From: Amanda Scholes
Sent: 09 January 2019 12:31
To: Planning Scanning
Subject: FW: LU/223/18/PL

From: Roger Spencer
Sent: 09 January 2019 12:14
To: Anita Gardner
Subject: RE: LU/223/18/PL

From: Roger Spencer
Sent: 08 January 2019 17:11
To: Karl Roberts
Cc: Anita Gardner
Subject: LU/223/18/PL

Proposed Floor Plans

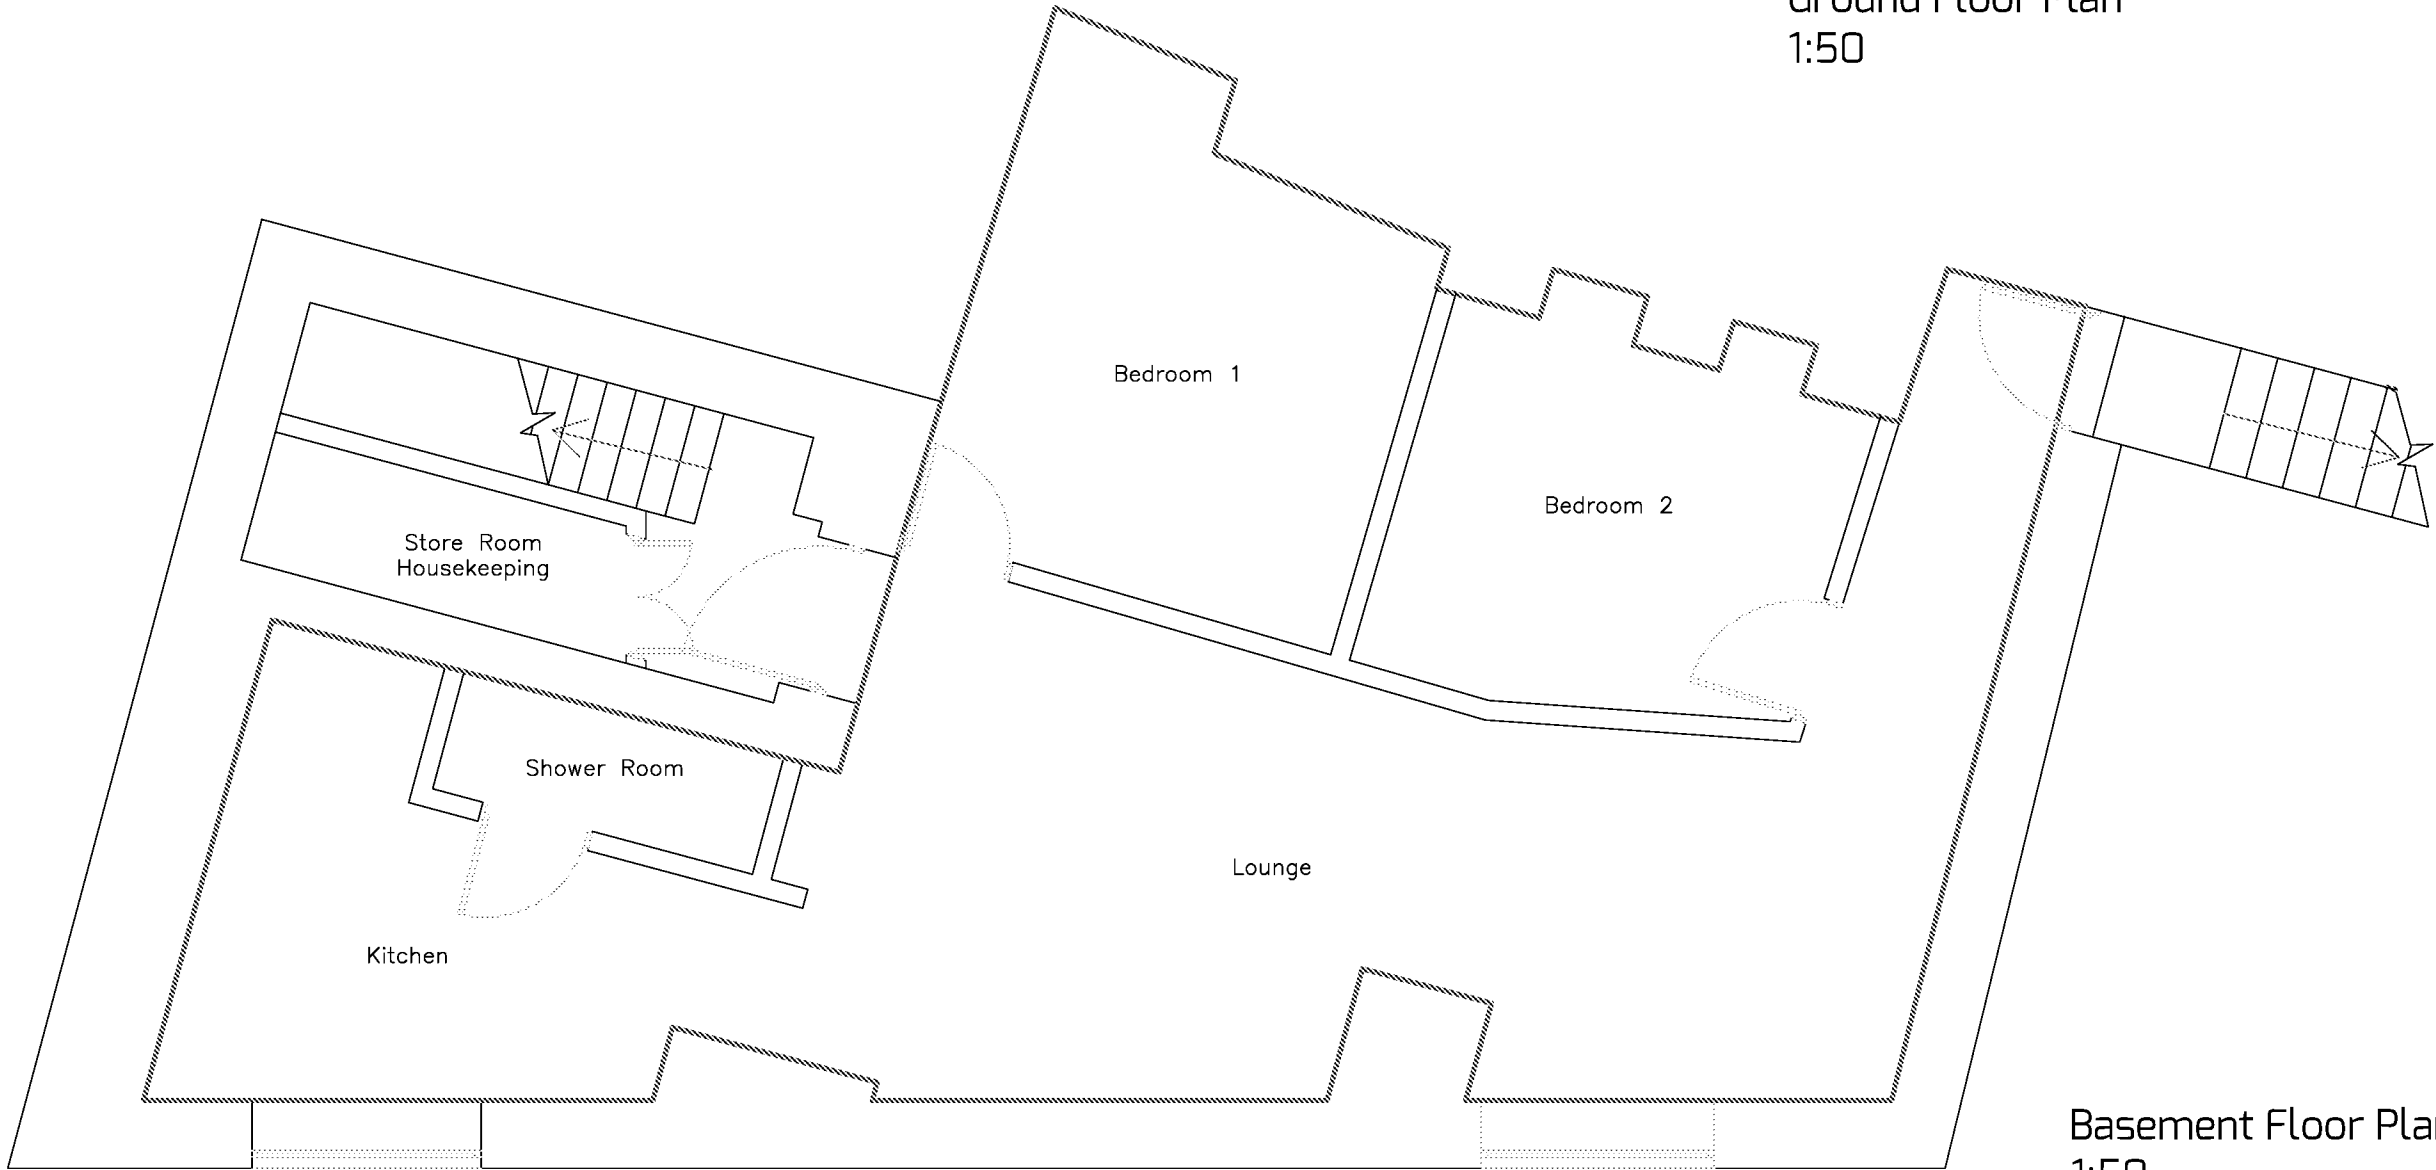
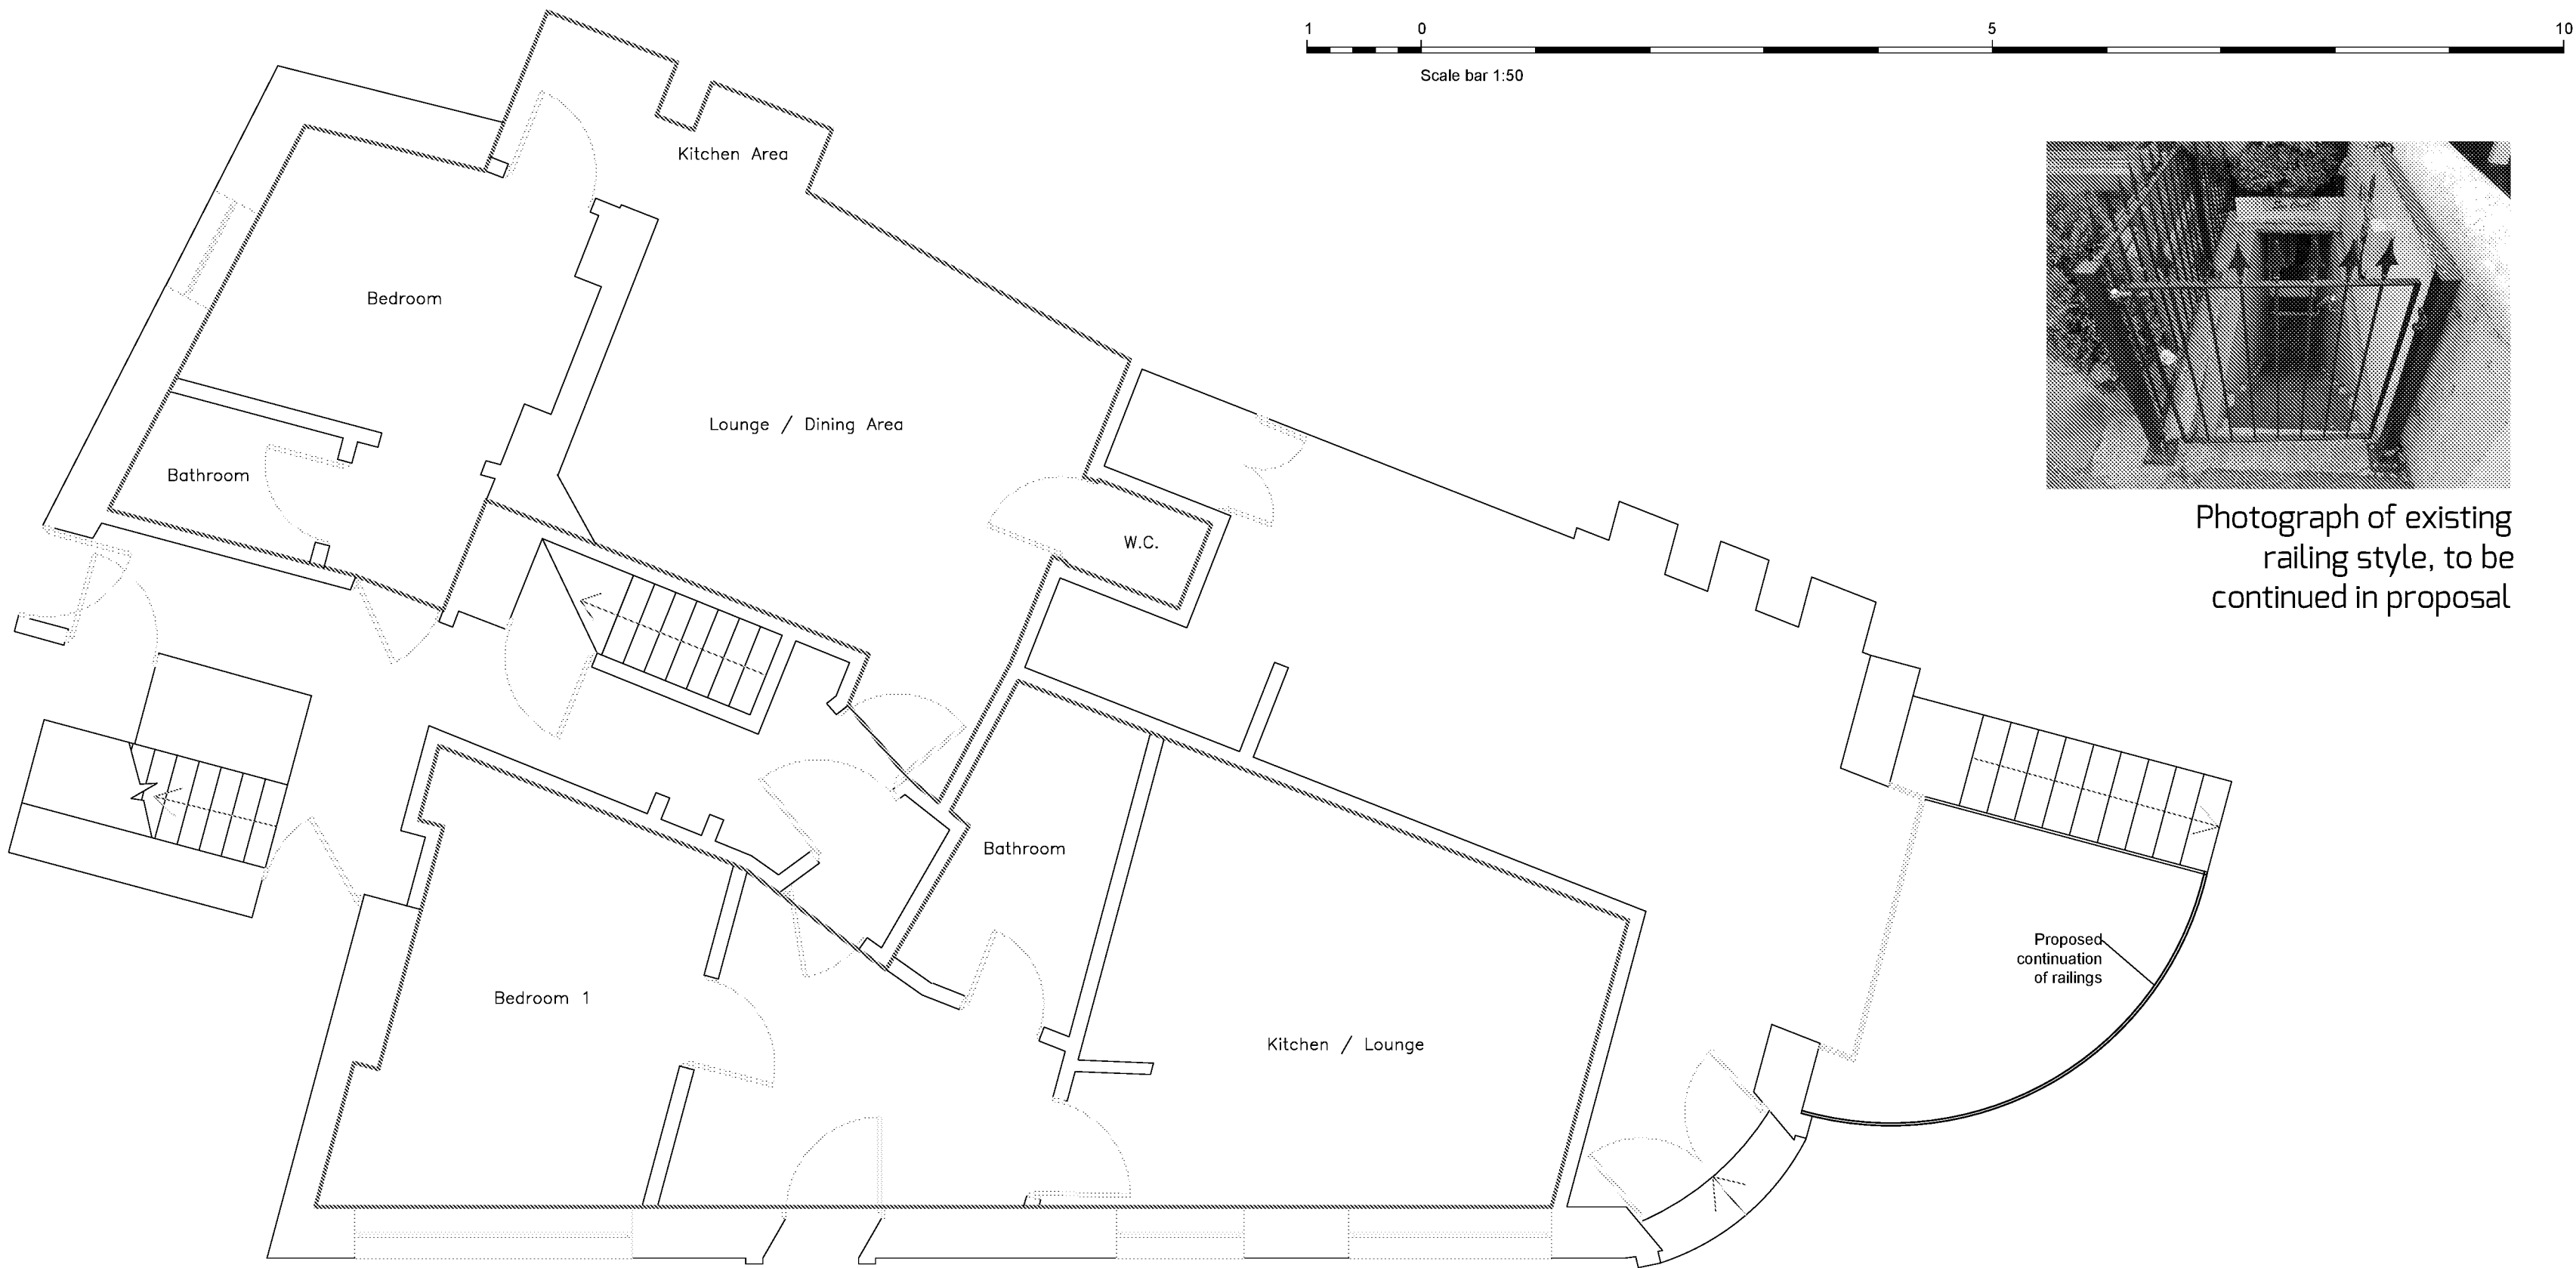
They may consider relaxing their position when it relates to new sites (because these can be better designed) but basement occupation (which this one is) still has risk; so they won't be withdrawing their objection in this case.
